Cedar Lodge, North Side, Steeple Aston
19/02465/LB
Creation of a jib door and associated stair

Jenny Ballinger, 24th January 2020

PART PLAN SHOWING JIB DOOR INTERVENTION 1:20

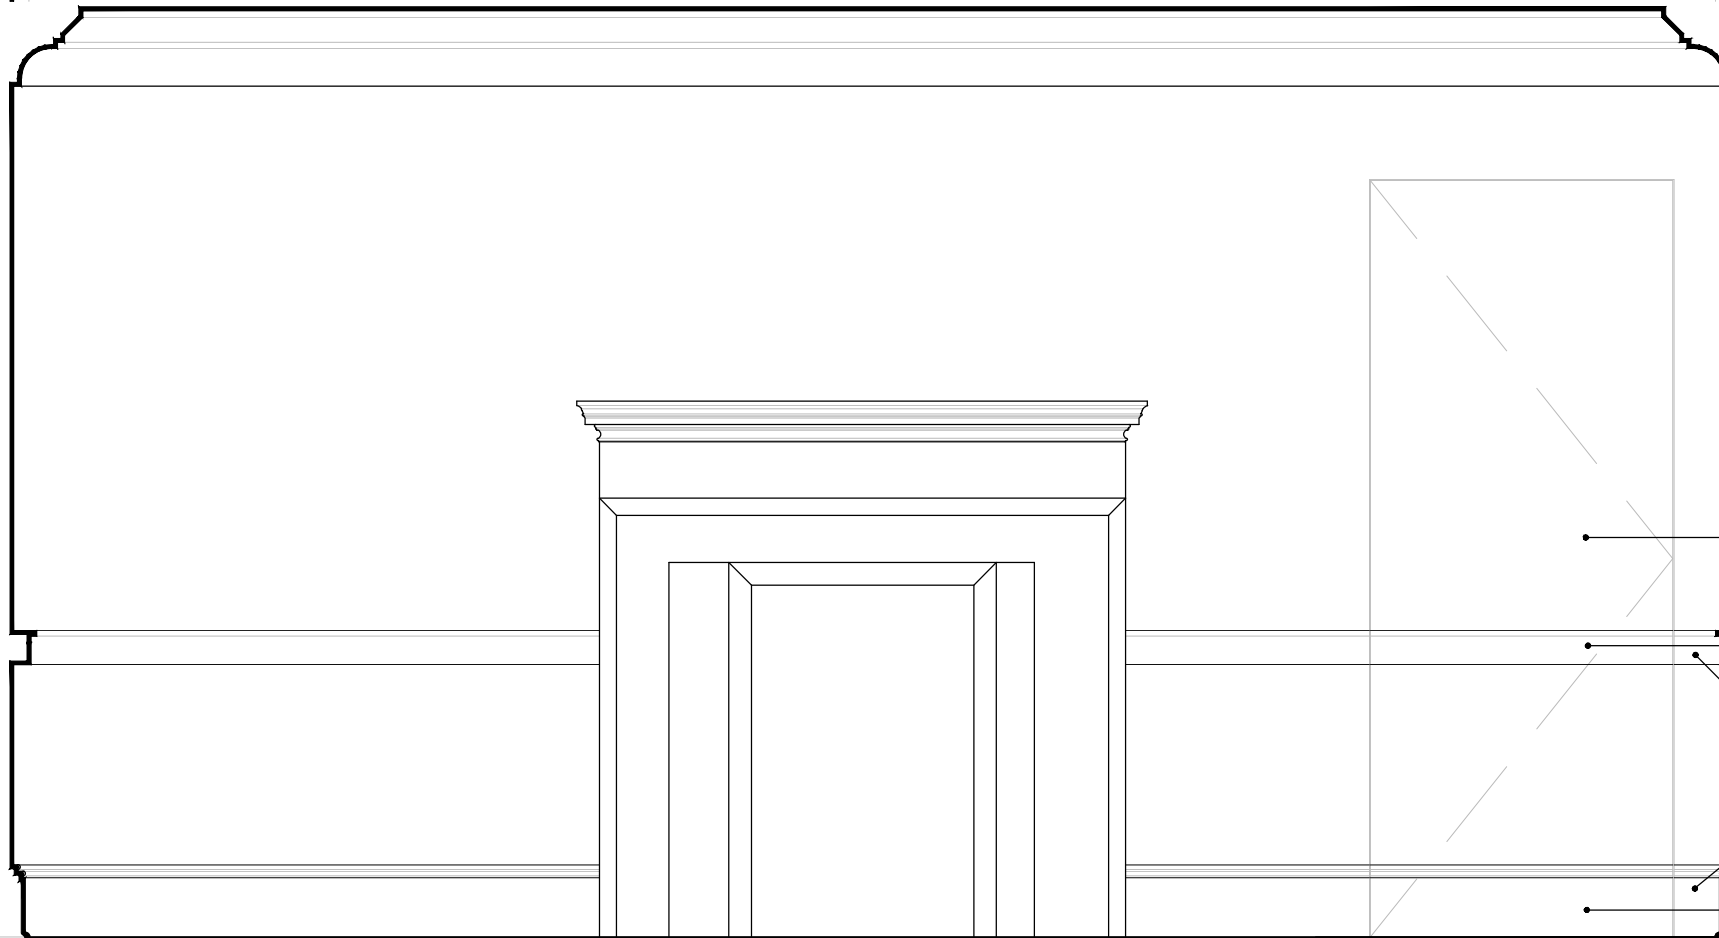
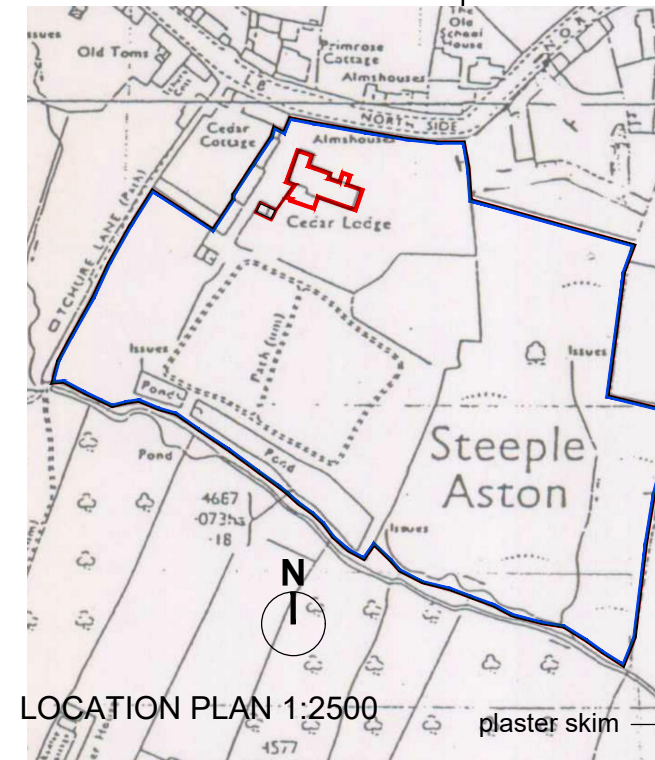
- The fundamental issue is that the proposed development breaches through two physically and functionally distinct areas of the building which causes harm to an understanding of the evolution of the plan form of the building. Regardless of the precise historic evolution of the building the internal character of the 'service wing' is different to that of the principal property which is reflected in the change of levels, lower ceiling heights, relative size of rooms etc.

- In previous applications it was thought that the only historic fabric to be lost was the walling in the gable end, however the return visit to the site revealed that it would also involve the loss of part of the lath and plaster ceiling (which had already been taken down without consent) and ceiling joists in the service wing in order to allow for headroom above the stairs between the two phases of the building.

- The changes proposed in this application are considered to cause harm to the significance of this area of the building. An alternative solution for an ensuite for this bedroom has been agreed upon and granted listed building consent. There are therefore no public benefits and the purely private benefits of the particular preferences of the current owners are not considered to outweigh the harm caused.
- The proposed development is recommended for refusal.

SECTION LOOKING WEST 1:50

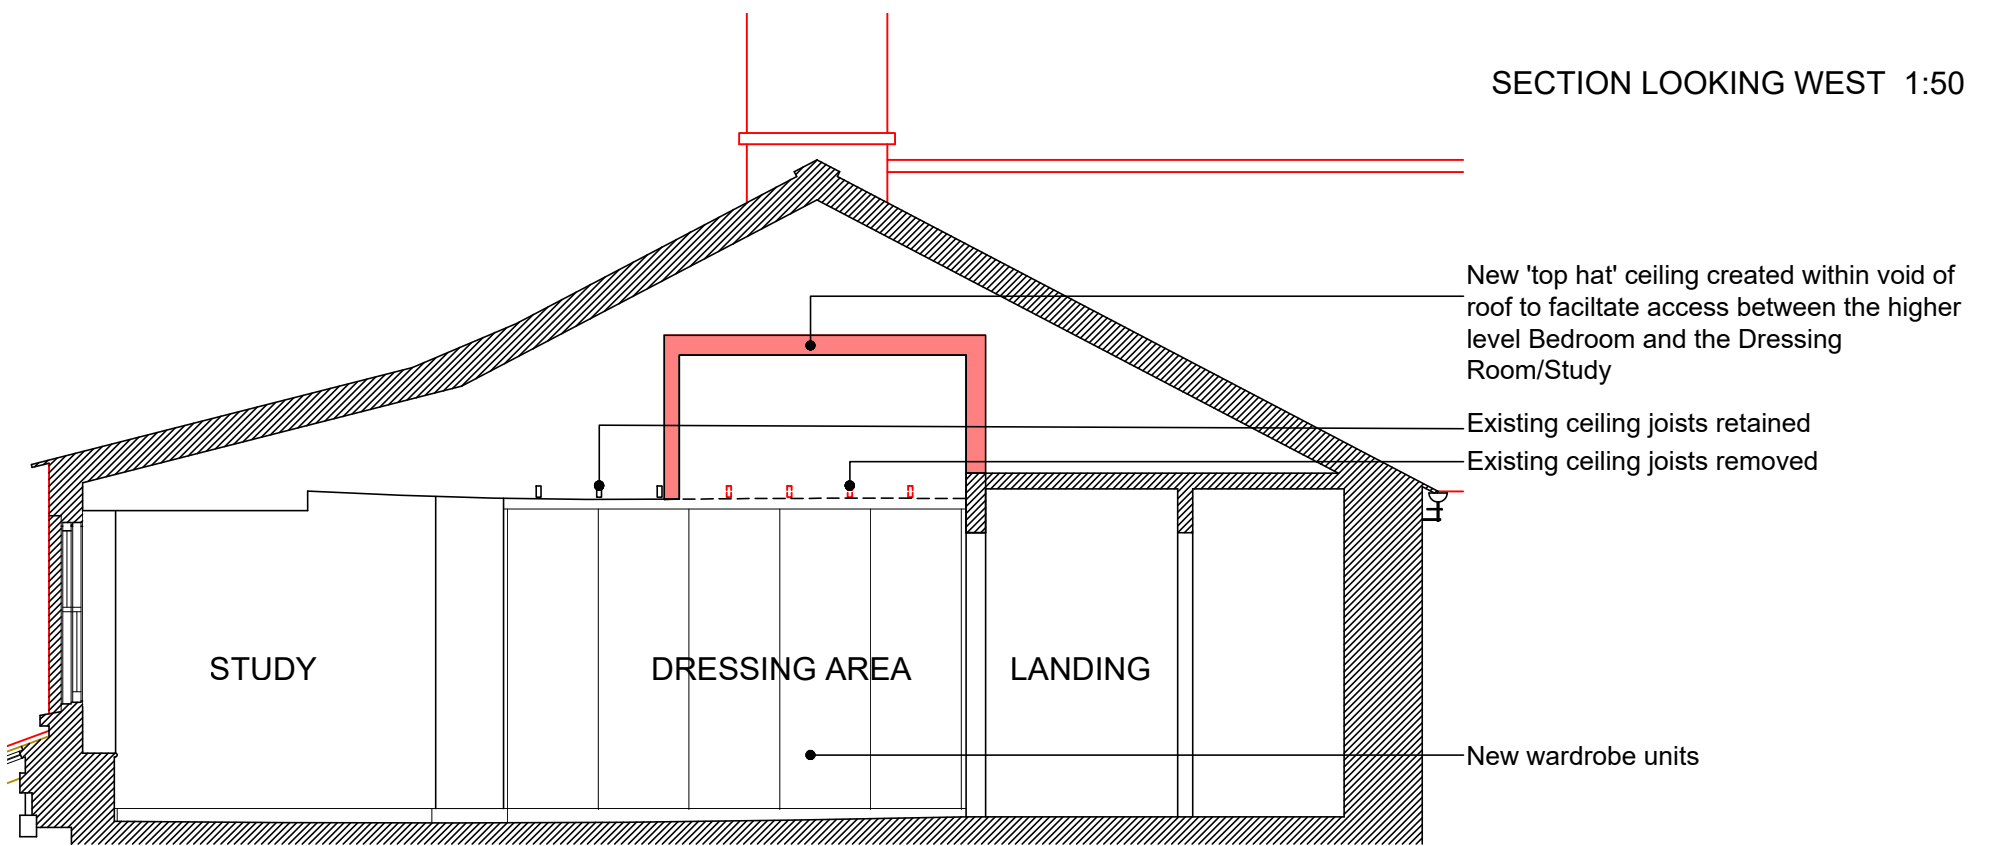
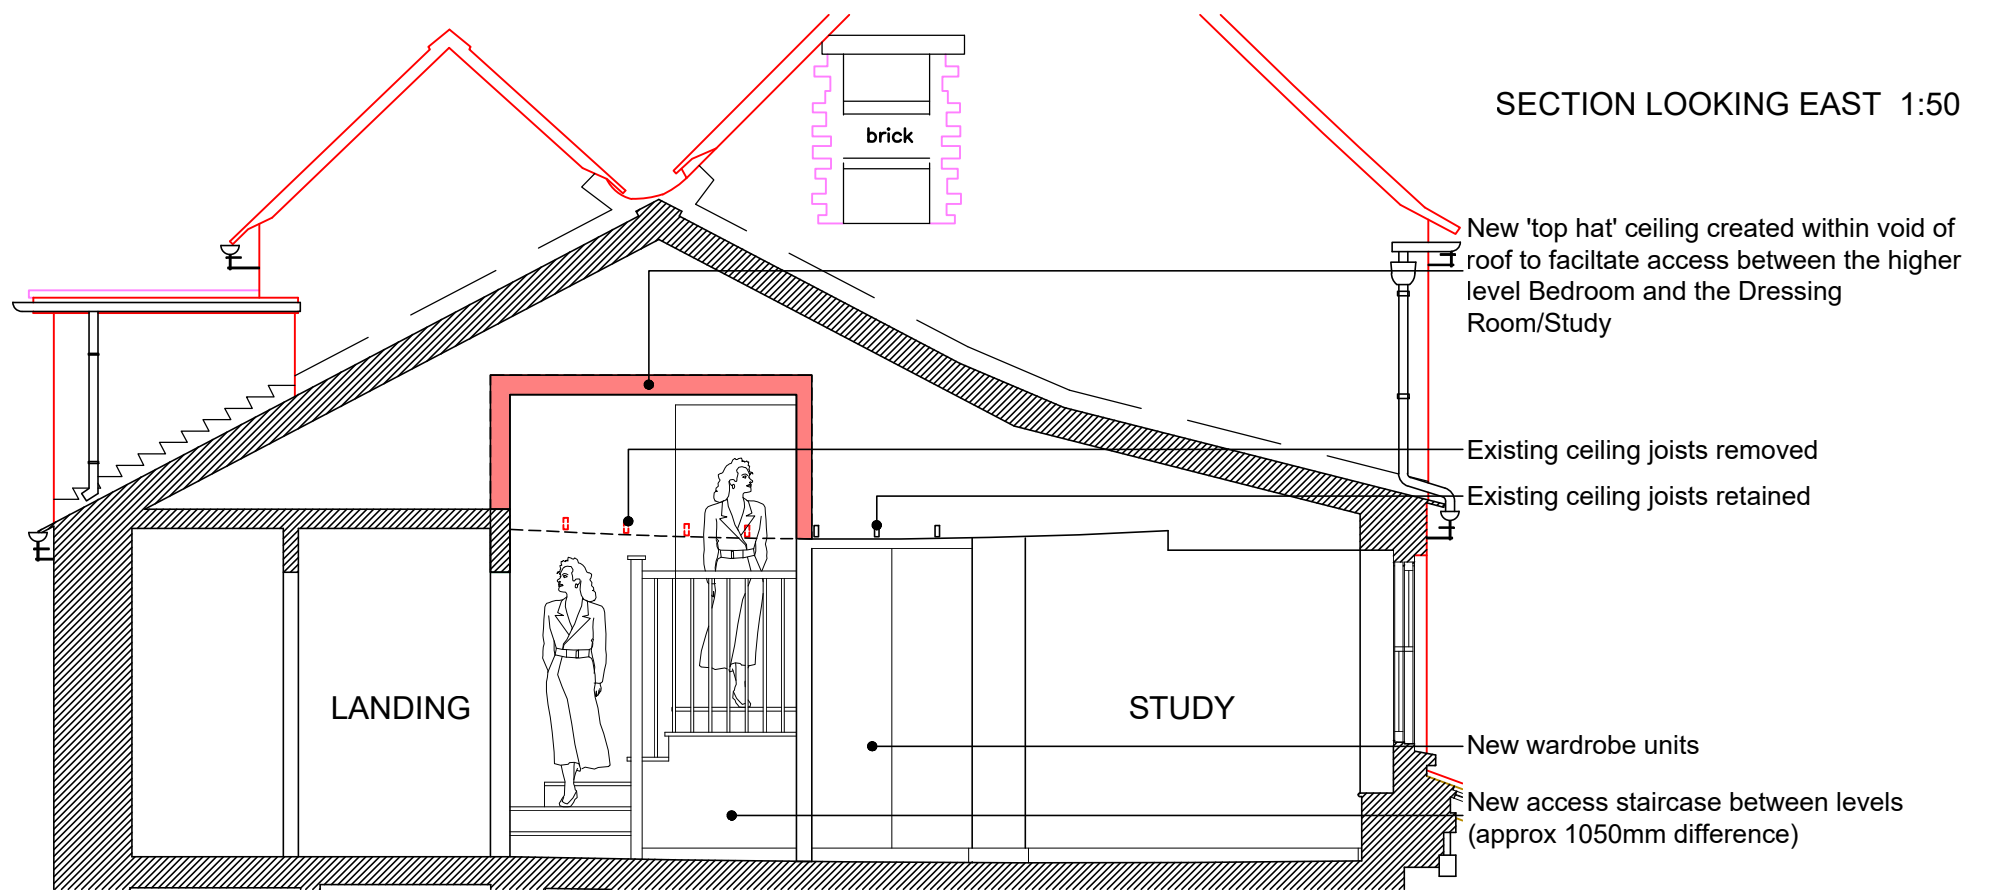
This application contains additional information relating to the construction of the proposed jib door, which would require the loss of a section of the ceiling joists. This information was not contained within earlier applications.
